<b>Application Ref:</b>	3/2025/0346			 Ribble Valley Borough Council <a href="http://www.ribblevalley.gov.uk">www.ribblevalley.gov.uk</a>				
<b>Date Inspected:</b>	14/05/26	<b>Site Notice:</b>	24/04/26					
<b>Officer:</b>	LH							
<b>DELEGATED ITEM FILE REPORT:</b>					<b>APPROVAL</b>

<b>Development Description:</b>	Change of use of agricultural land to create an additional 95 car parking spaces
<b>Site Address/Location:</b>	Hawkshaw Farm, Longsight Road, Clayton le Dale, BB2 7JA.

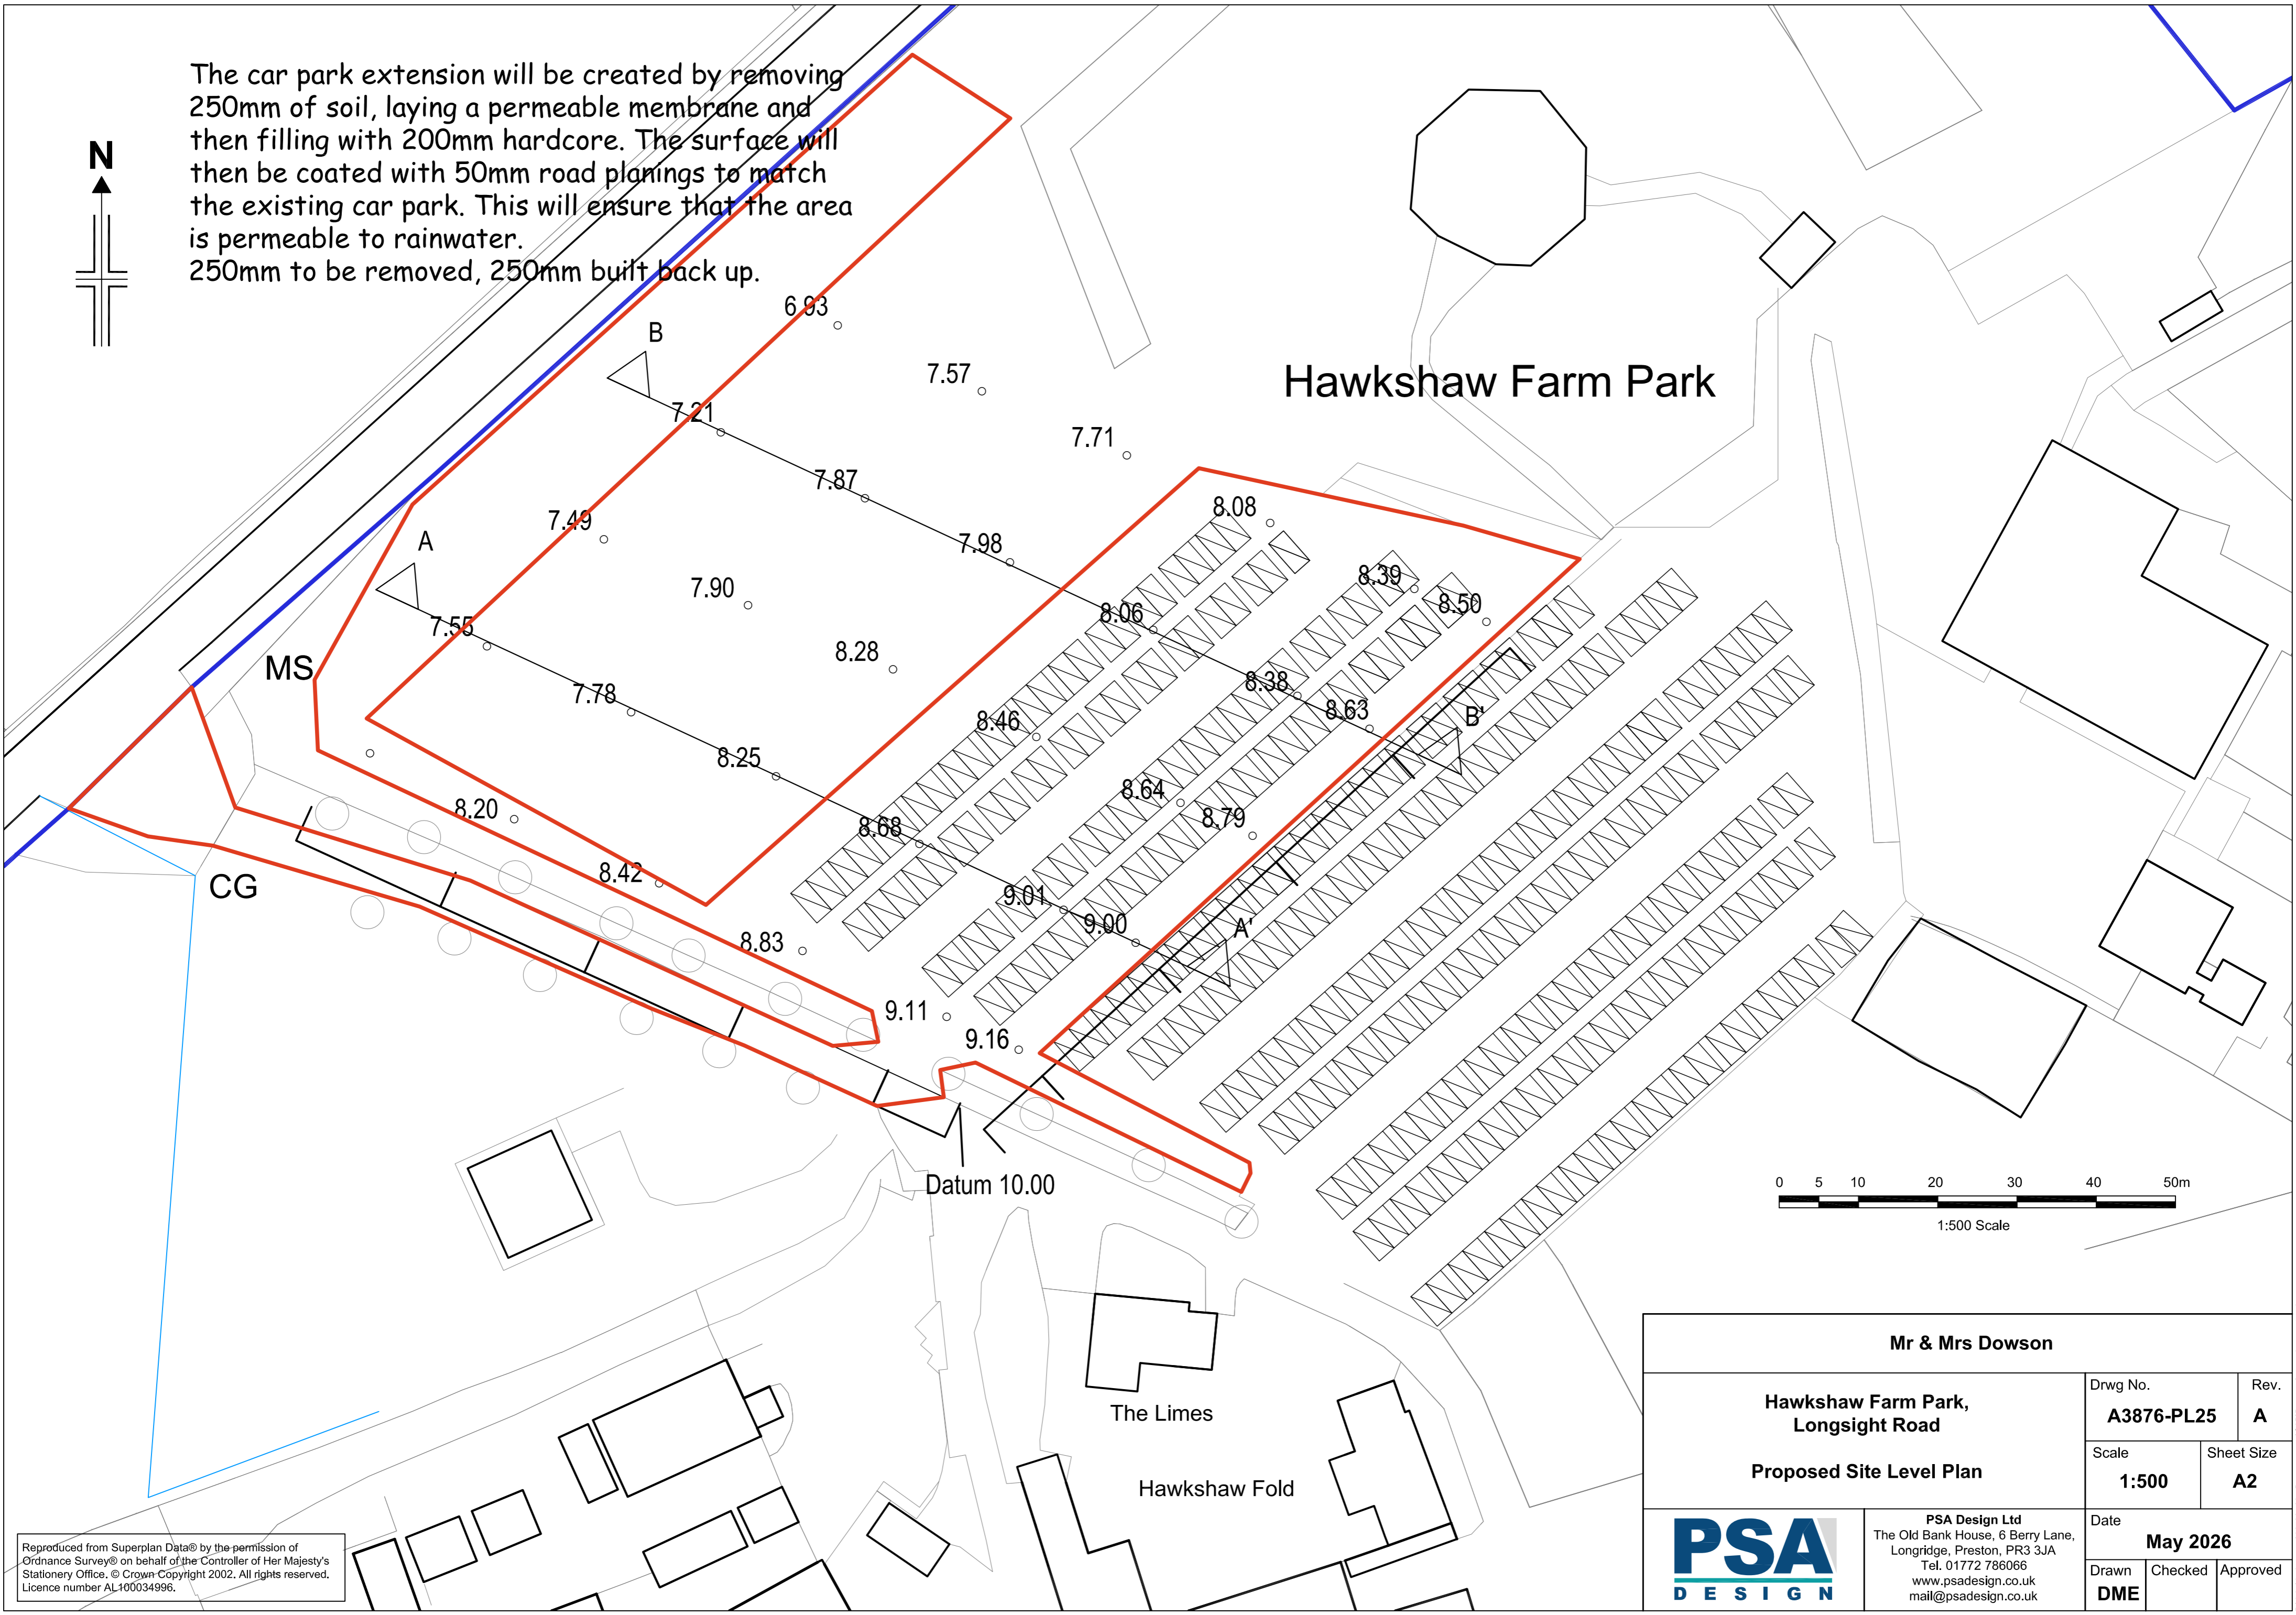
The applicant was invited to amend the scheme by omitting a bund initially proposed along the A59 and revising the layout to remove the furthest row of parking proposed closest to the A59 and repositioning these spaces to the east. This is considered to result in an improved visual impact and increase the green buffer retention between the car park and A59.
